**West Suffolk**  
Council

**16 December 2022 – Deadline 4**

## **Application by Sunnica Ltd for an Order Granting Development Consent for the Sunnica Energy Farm Project**

### **Review of Environmental Masterplan [REP3-022]**

Drawing Title: FIGURE 10-14F LANDSCAPE MASTERPLAN CABLE ROUTE TO BURWELL SUBSTATION

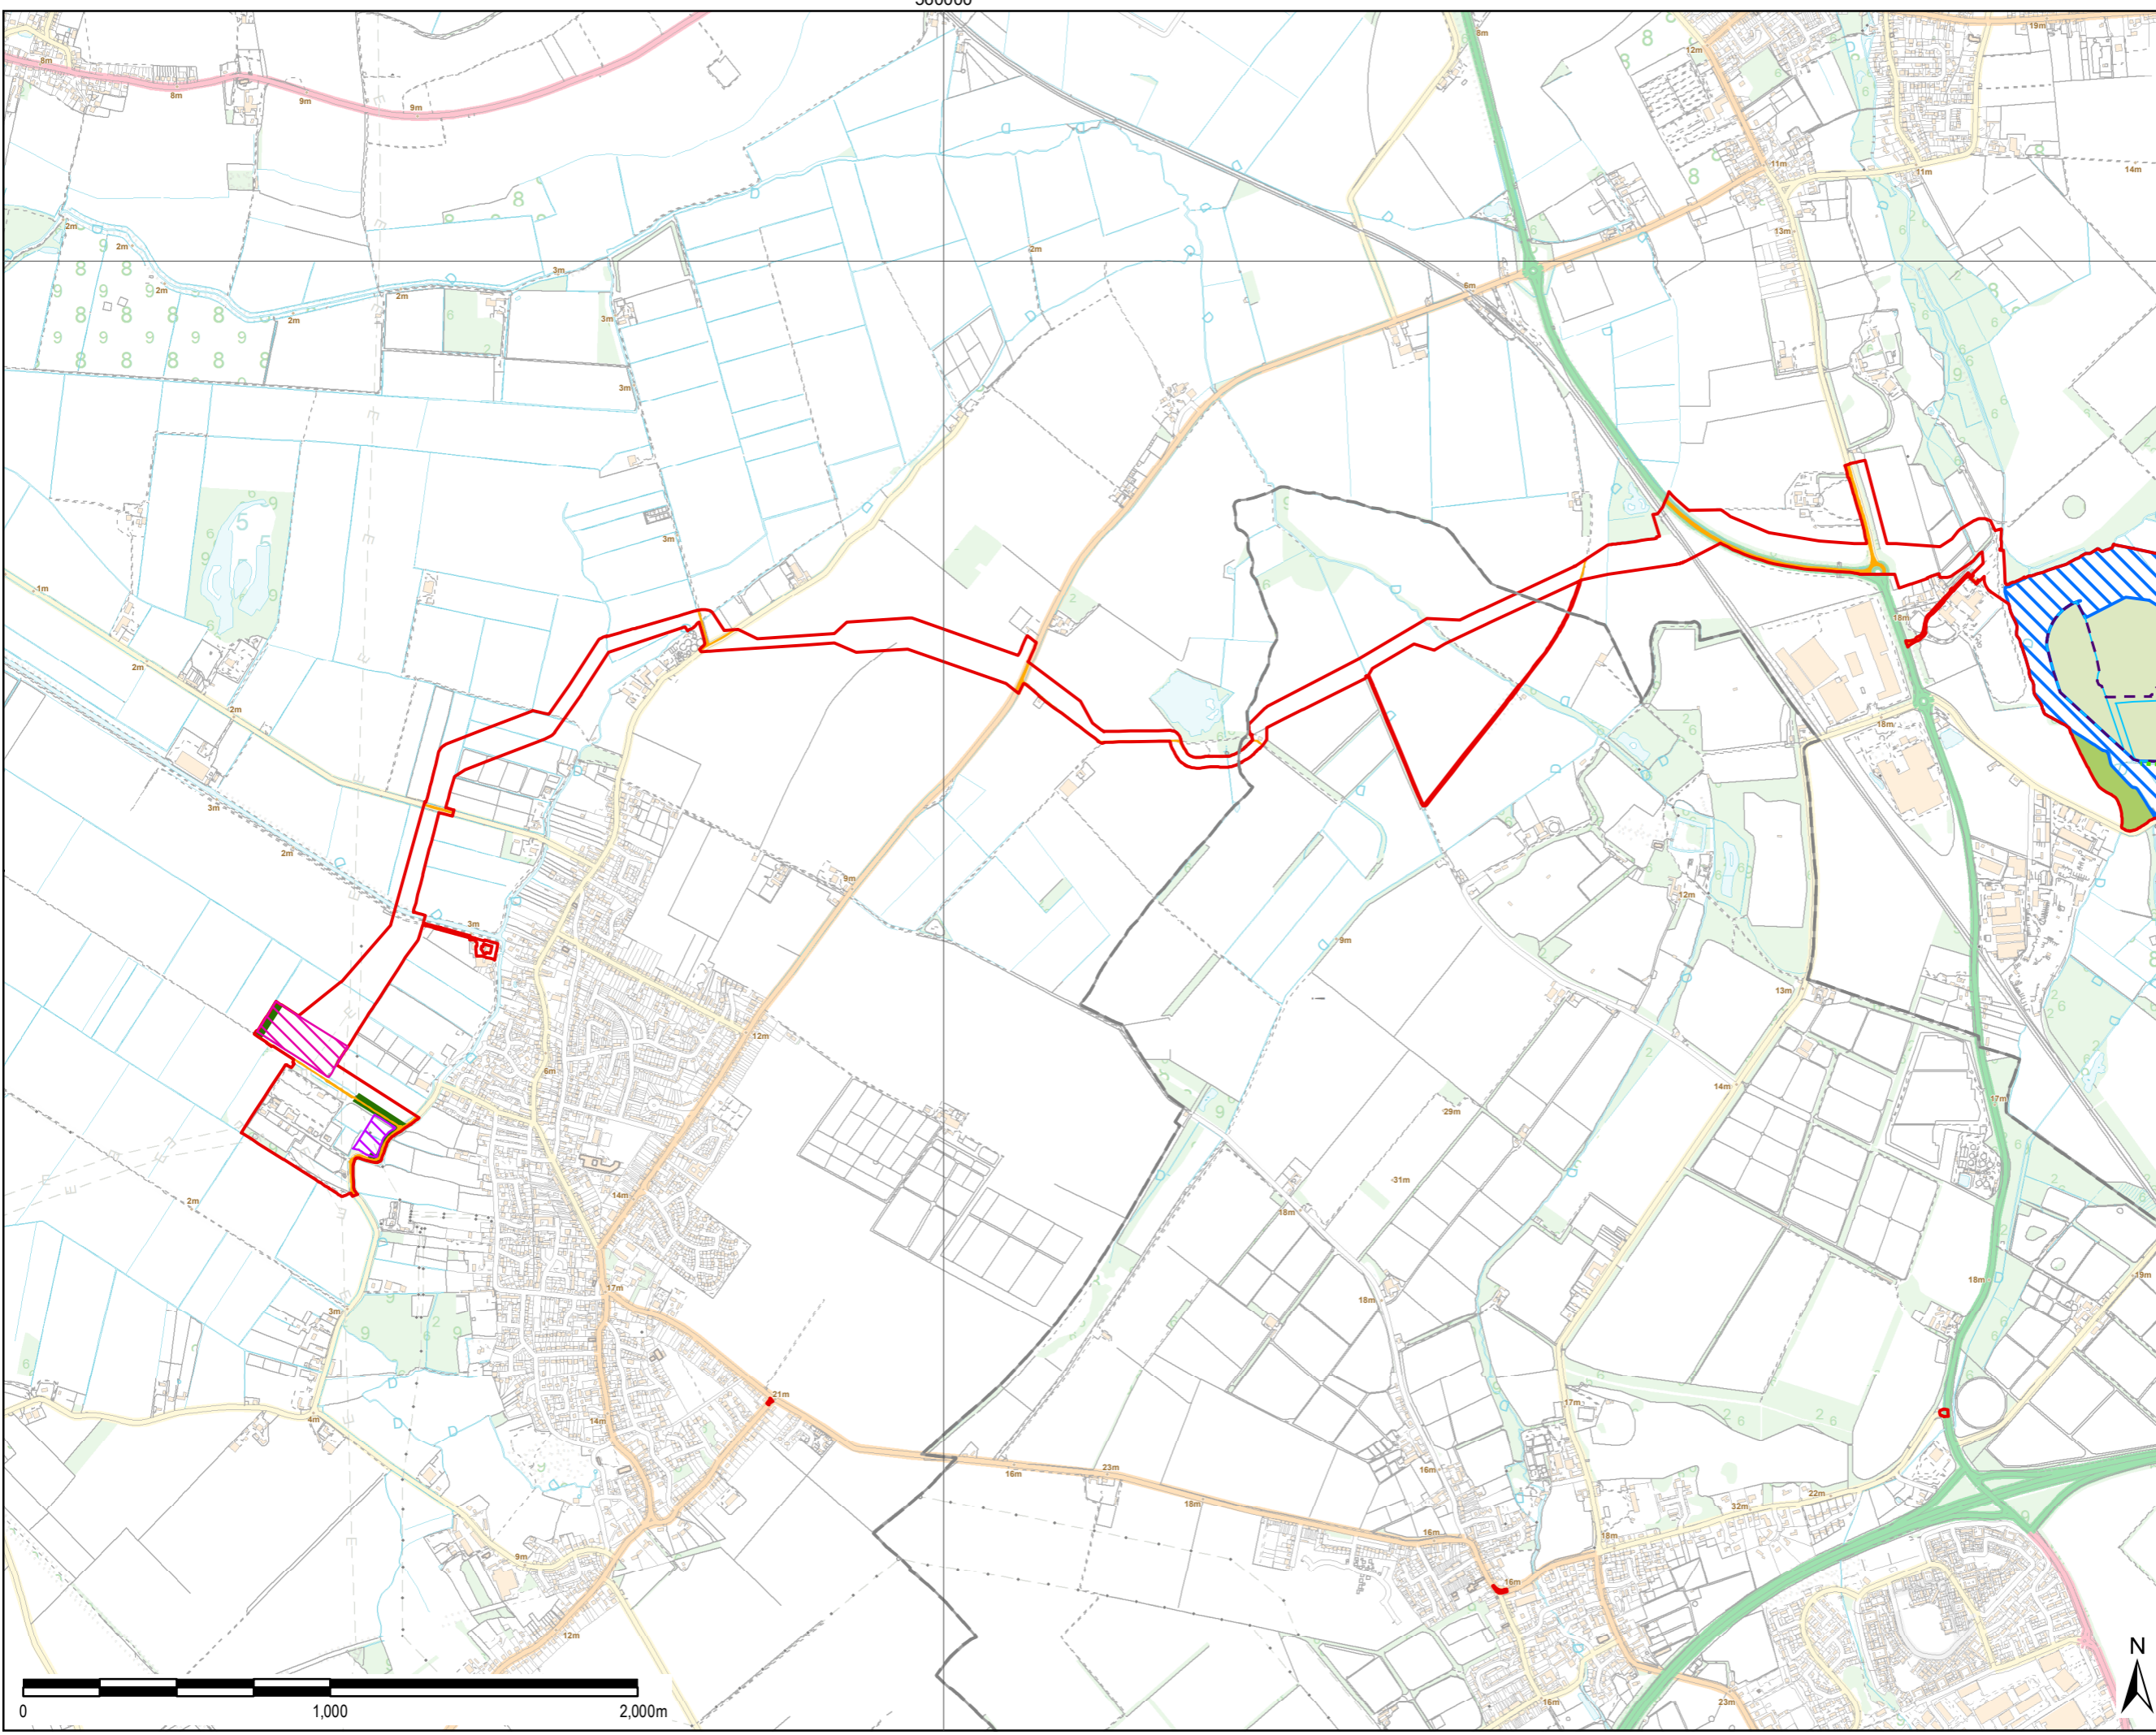
- The proposed arable flora plots are inadequate.
- For the Cable Route to Burwell - does the lack of 'coloured in' areas on the drawing mean that existing habitat will be retained/reinstated?
- The areas of retained woodland are difficult to read on the plan.
- Existing PRow as well as proposed permissive routes should be included to show connectivity.
